from
**Southern
Water**

Our ref
PLAN-038173

Proposal: Conversion of existing barn to 1 No. residential dwelling with associated parking (resubmission following Y/137/20/PL). This site is in CIL Zone 3 & is CIL Liable as new dwelling.

Site: Y/33/21/PL: - Plum Pudding Barn, Hoe Lane, Flansham, PO22 8NS.

PROPOSED BLOCK PLAN, Sc. 1:500

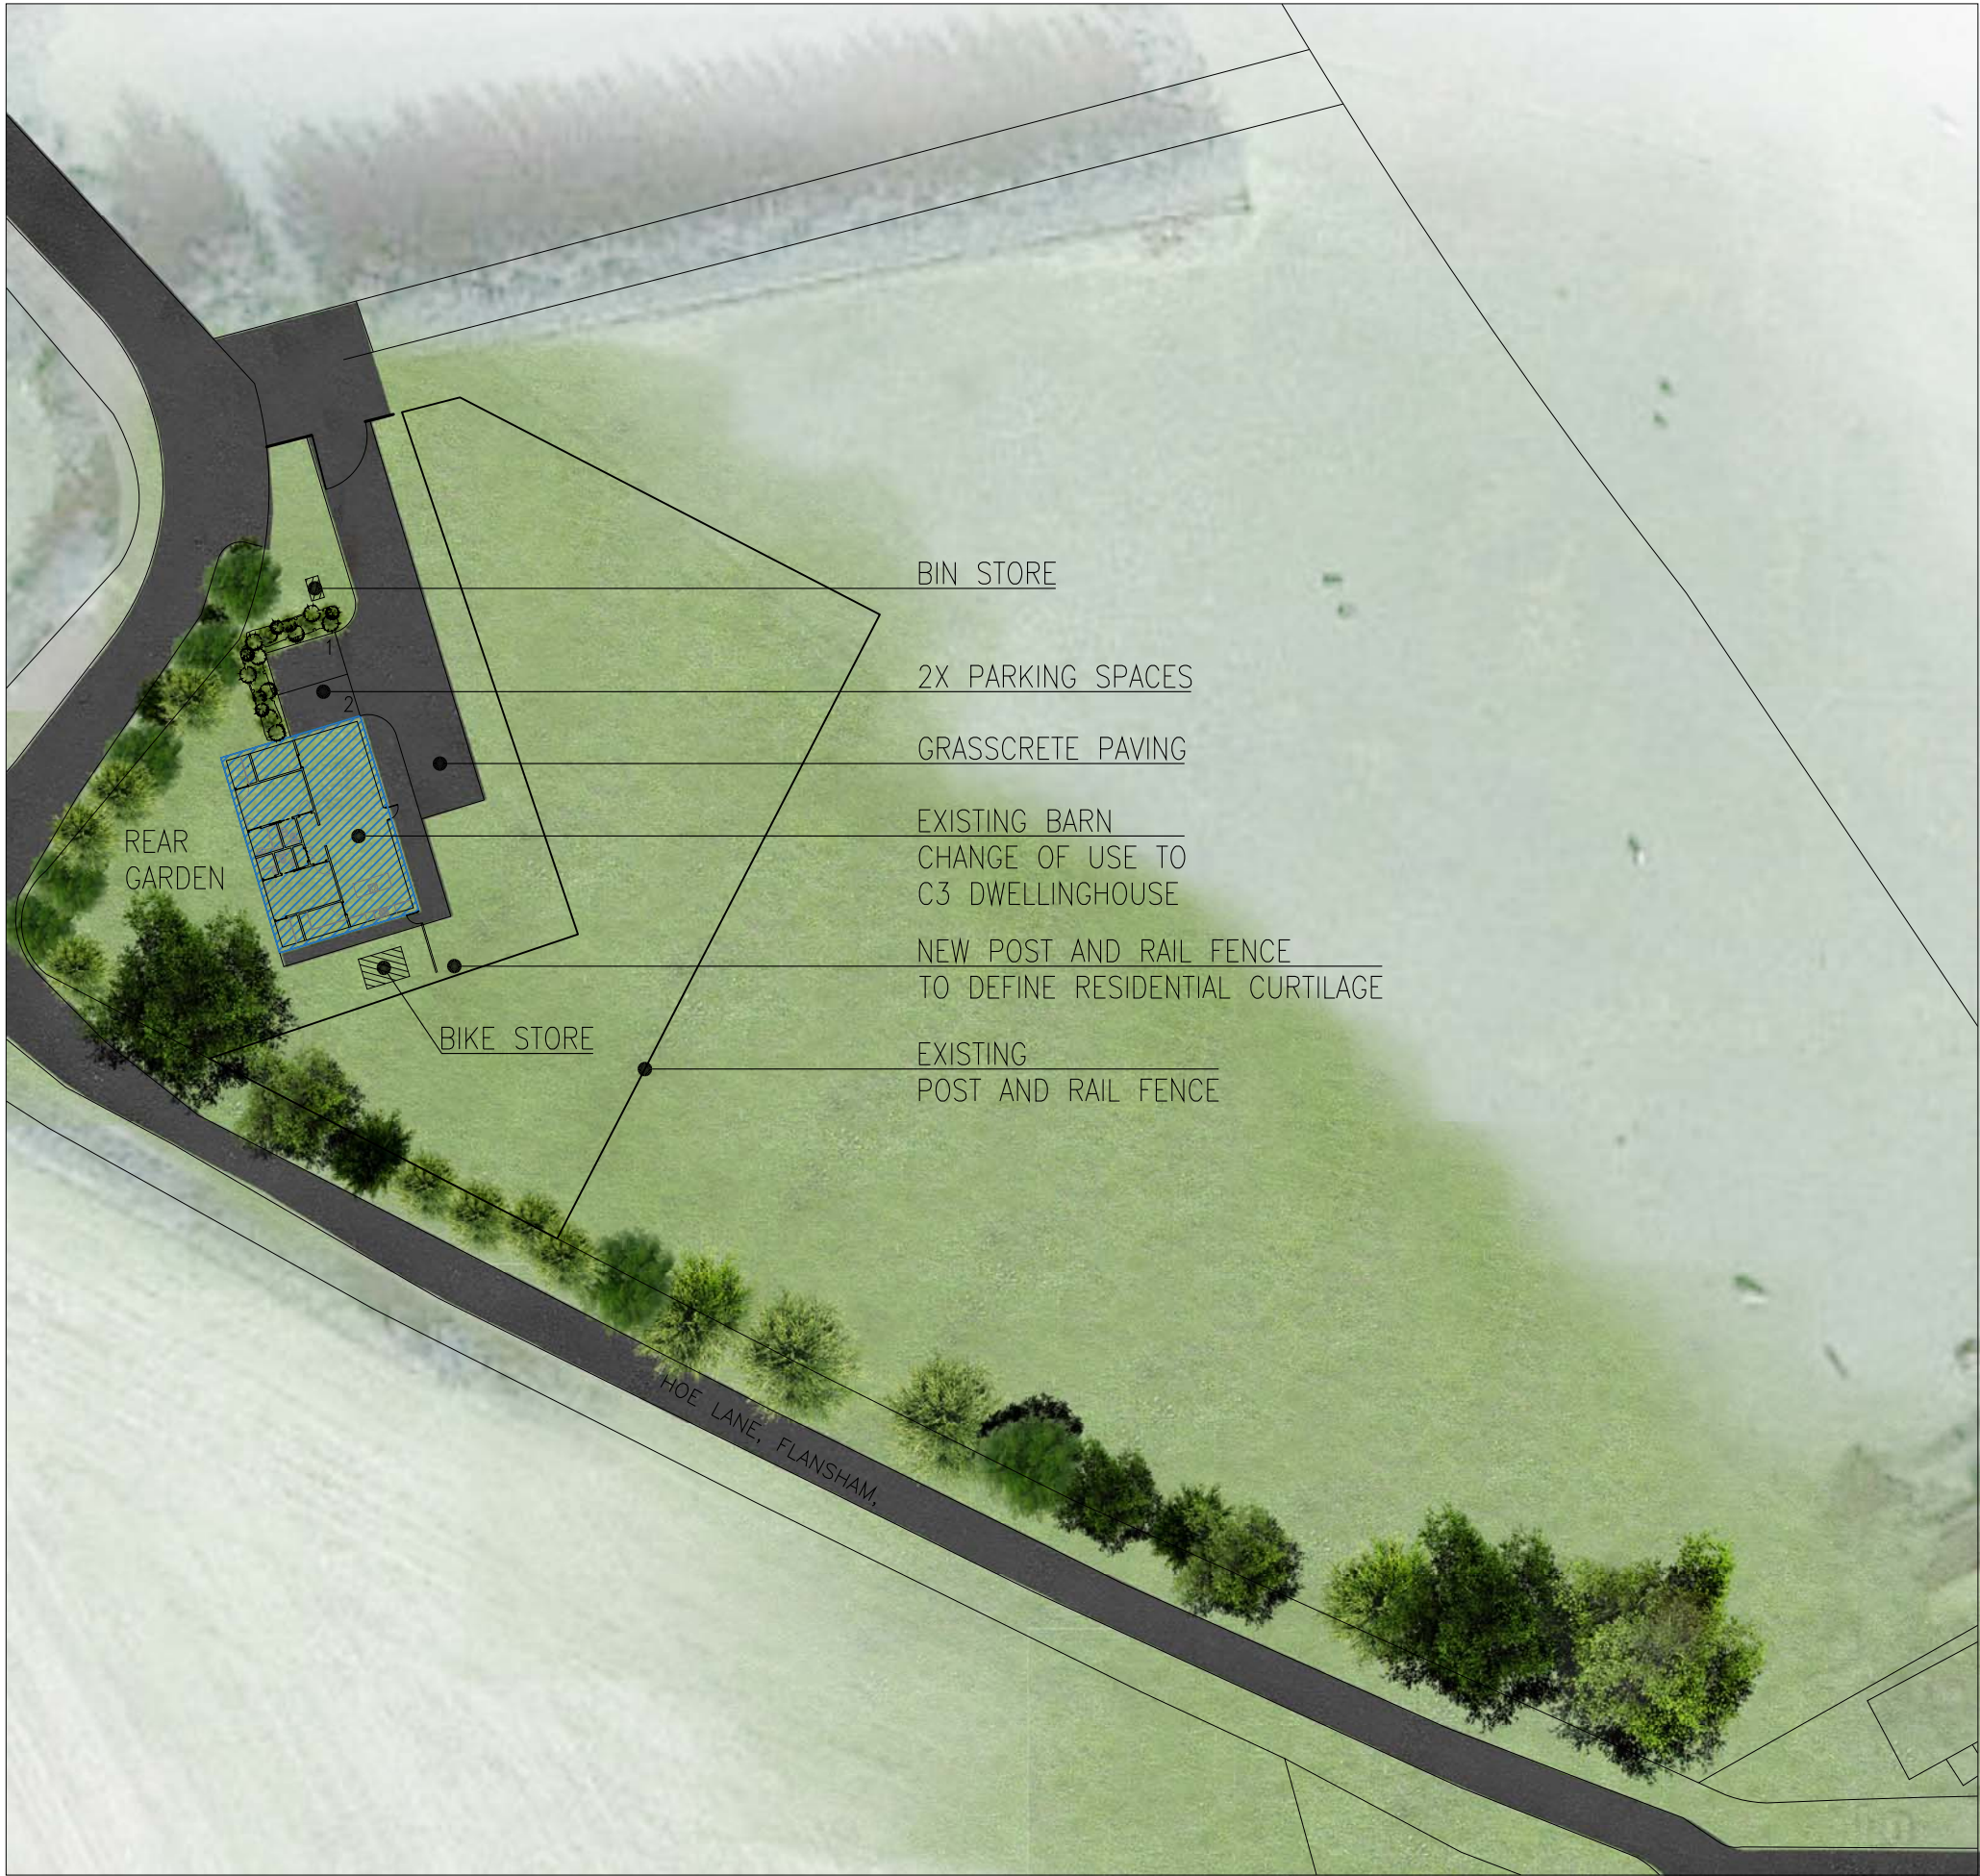
Please see the attached extract from Southern Water records showing the approximate position of our existing public foul rising main within the development site. The exact position of the public assets must be determined on site by the applicant in consultation with Southern Water before the layout of the proposed development is finalised.

- The public foul rising main requires a clearance of 3 metres on either side of the rising main to protect it from construction works and to allow for future access for maintenance.
- No new development or new tree planting should be carried out within 3 metres of the external edge of the public rising main without consent from Southern Water.
- No new soakaway, swales, ponds, watercourses or any other surface water retaining or conveying features should be located within 5 metres of a public rising main.
- All existing infrastructure should be protected during the course of construction works.

Southern Water would not support the proposals for a septic tank or private treatment plant in the presence of a public foul sewerage network in the close vicinity of the development site. The foul sewerage shall be disposed in accordance with Part H1 of Building Regulations hierarchy found at: gov.uk/government/publications/drainage-and-waste-disposal-approved-document-h

Our initial investigations indicate that there are no public surface water sewers in the area to serve this development. Alternative means of draining surface water from this development are required. This should not involve disposal to a public foul sewer and should be in line with the Hierarchy of H3 of Building Regulations with preference for use of soakaways.
